Rezoning Transportation Analysis

Petition Number: 2022-116

Date	Description
12-28-22	First Review (IW)

# RZ-2

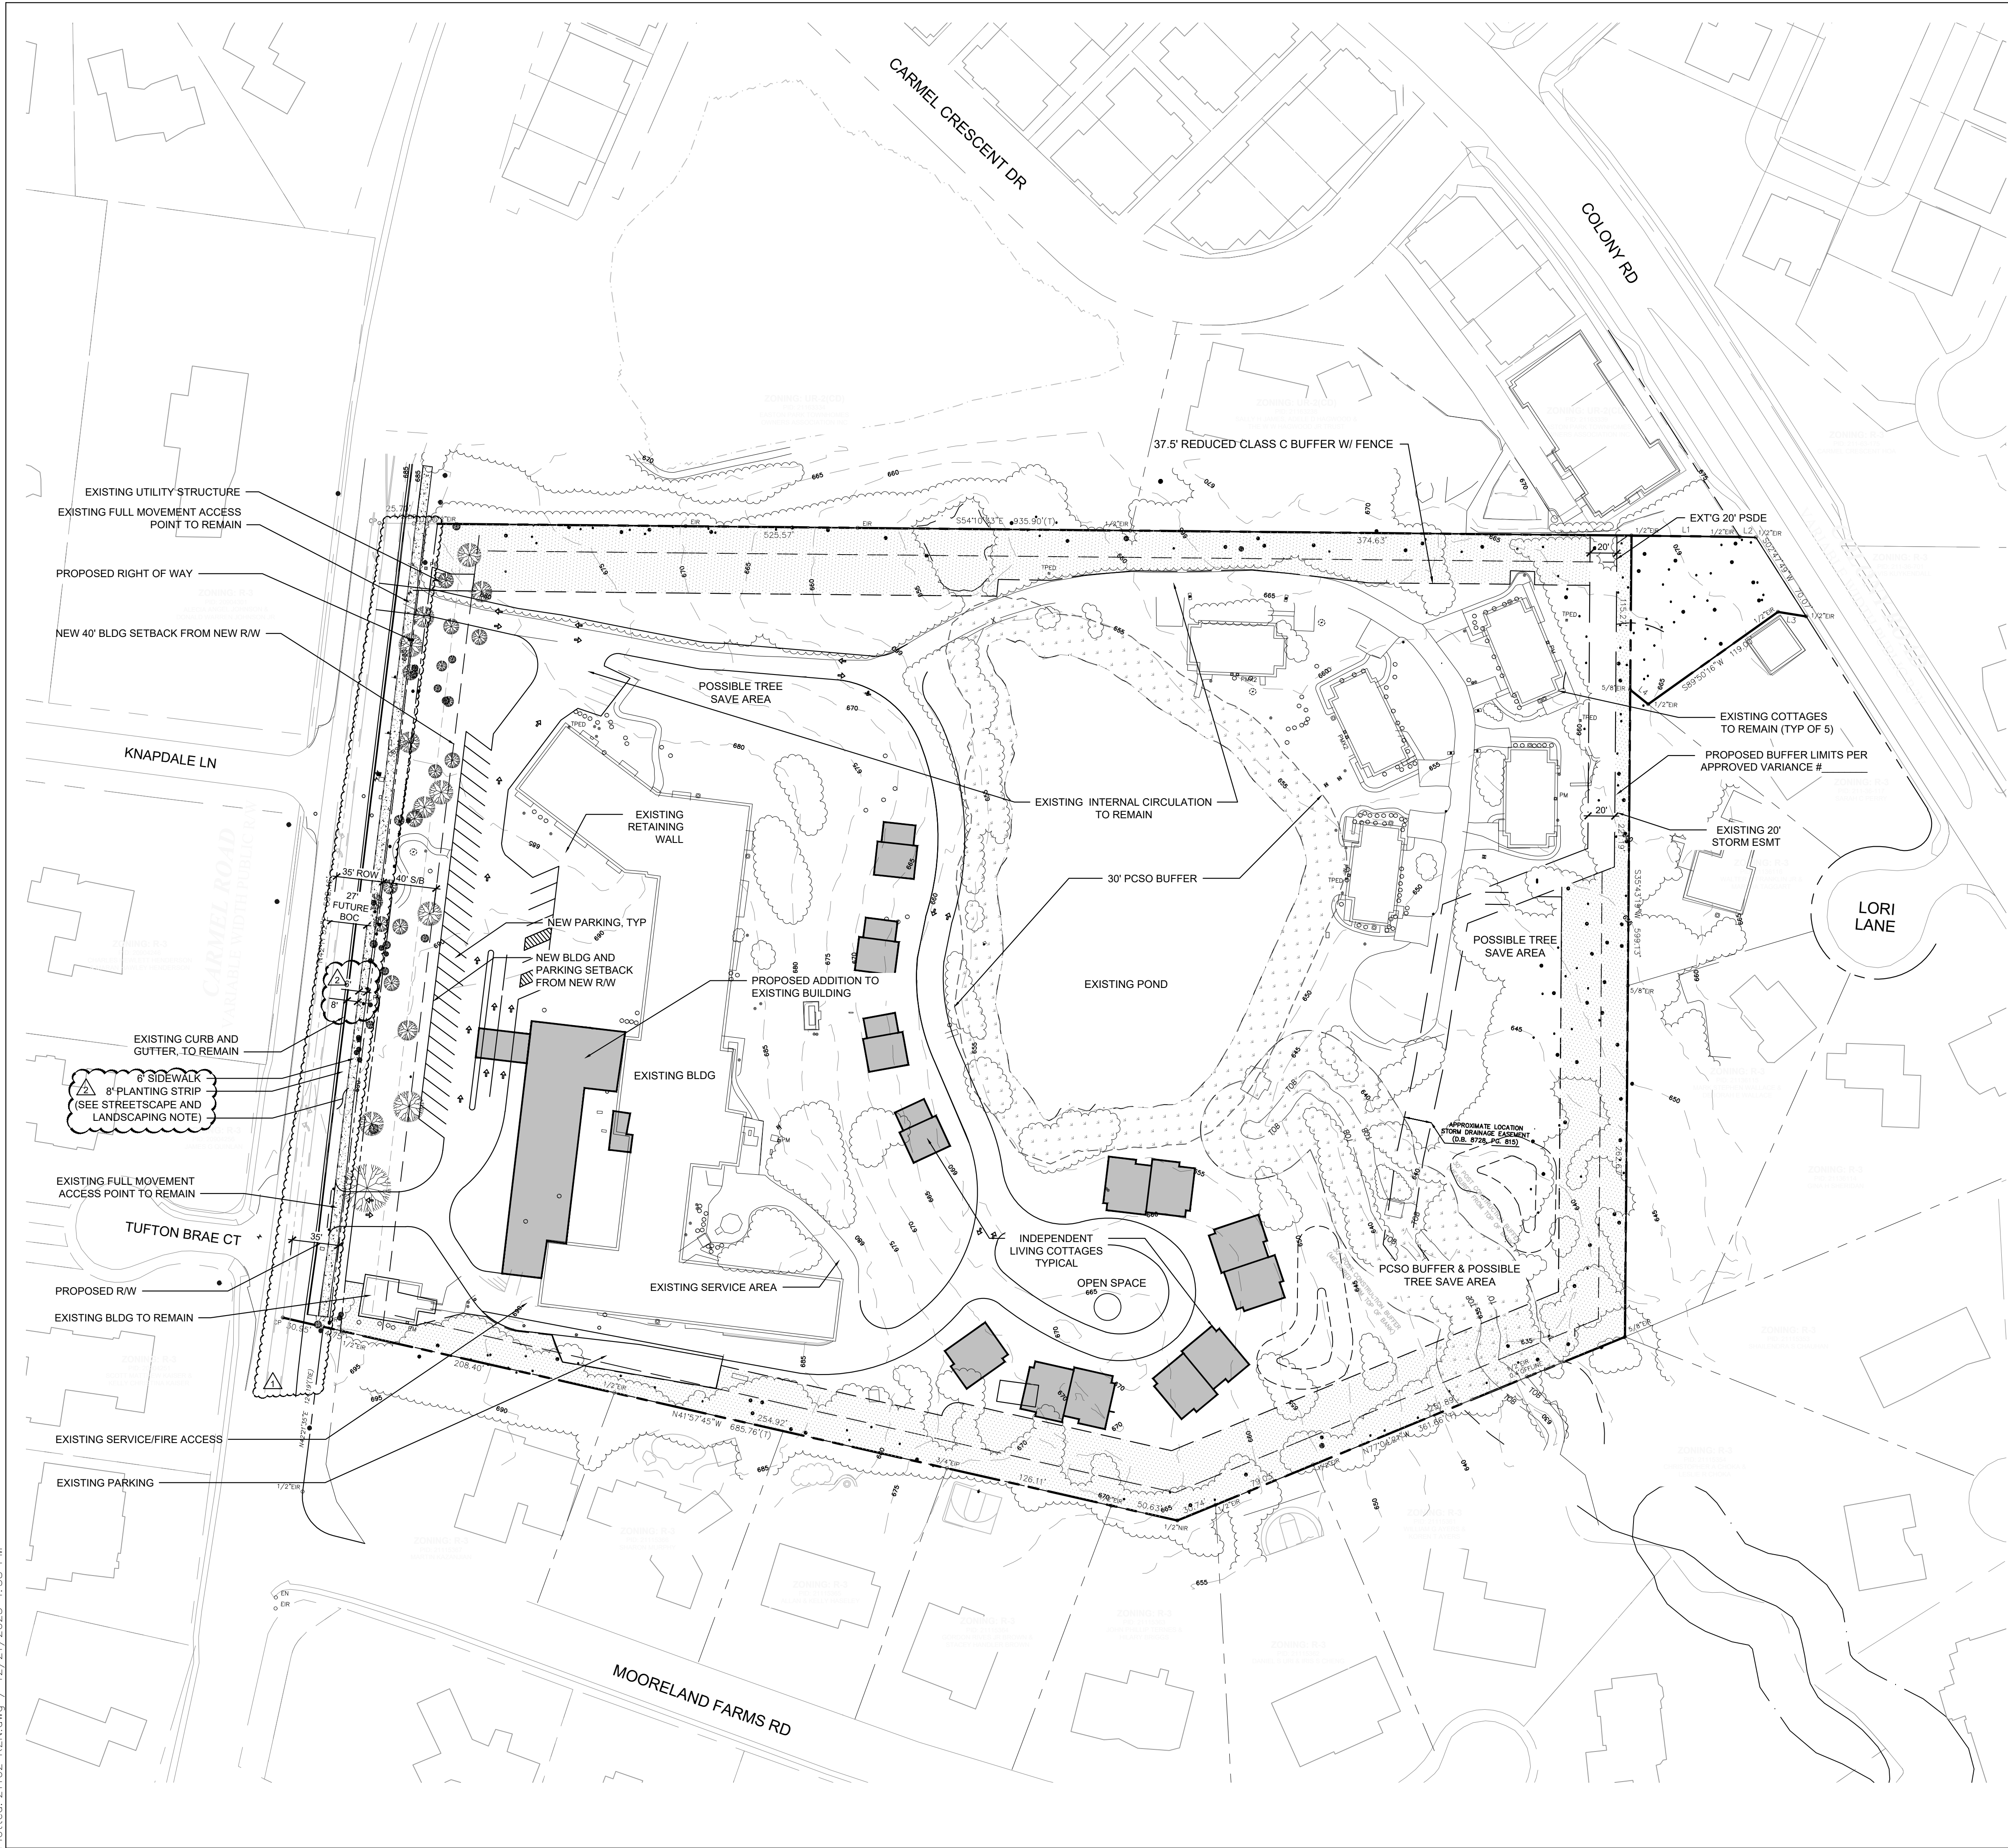
- a. **Carmel Road:** Location of curb and gutter to be moved to 27 feet from roadway centerline to accommodate the Charlotte Streets Map with a roadway typical section of CLDSM 11.09 Minor Thoroughfare.
- b. **Colony Road:** Location of curb and gutter to be moved to 24 feet from roadway centerline to accommodate the Charlotte Streets Map with a roadway typical section of CLDSM 11.09 Minor Thoroughfare

Label and dimension the curb and gutter from the centerline for each road on the site plan.

3. Revise site plan and conditional note(s) to commit to dedicate 43 feet of right-of-way from the Carmel road centerline and 40 feet of right of way from the Colony Road centerline. The site plan shall label and dimension the right-of-way from the road centerline.
4. Per Chapter 20 revise site plan and conditional note(s) to commit to construct an 8-foot planting strip, and 6-foot sidewalk on Carmel Road or if the proposed dwelling units exceeds 12 per acre after verifying density, revise site plan and conditional note(s) to commit to construct an 8-foot planting strip, and 8-foot sidewalk along Carmel road. The wider sidewalk also meets the Charlotte WALKS Policy.

5. Revise site plan and conditional note(s) to commit to construct a buffered bicycle facility by locating the back of curb and gutter 27' from the center line to meet the Council-adopted Charlotte BIKES Policy.
6. Add a conditional note specifying "A Right-of-Way Encroachment Agreement is required for the installation of any non-standard item(s) (irrigation systems, decorative concrete pavement, brick pavers, etc.) within a proposed/existing City-maintained street right-of-way by a private individual, group, business, or homeowner's/business association. An encroachment agreement must be approved by CDOT prior to construction/installation. Contact CDOT for additional information concerning cost, submittal, and liability insurance coverage requirements."

7. Revise site plan and conditional note(s) to commit to restricting access off Colony Road to right-in / right-out.
8. Add a conditional note specifying “the Petitioner shall dedicate and convey in fee simple all rights-of-way to the City before the site’s first building certificate of occupancy is issued. CDOT requests rights-of-way set at 2’ behind back of sidewalk where feasible.”
9. Add a conditional note specifying “All transportation improvements will be approved and constructed before the site’s first building certificate of occupancy is issued. The petitioner may phase transportation improvements if said improvements and phasing are explicitly described in site plan notes.”
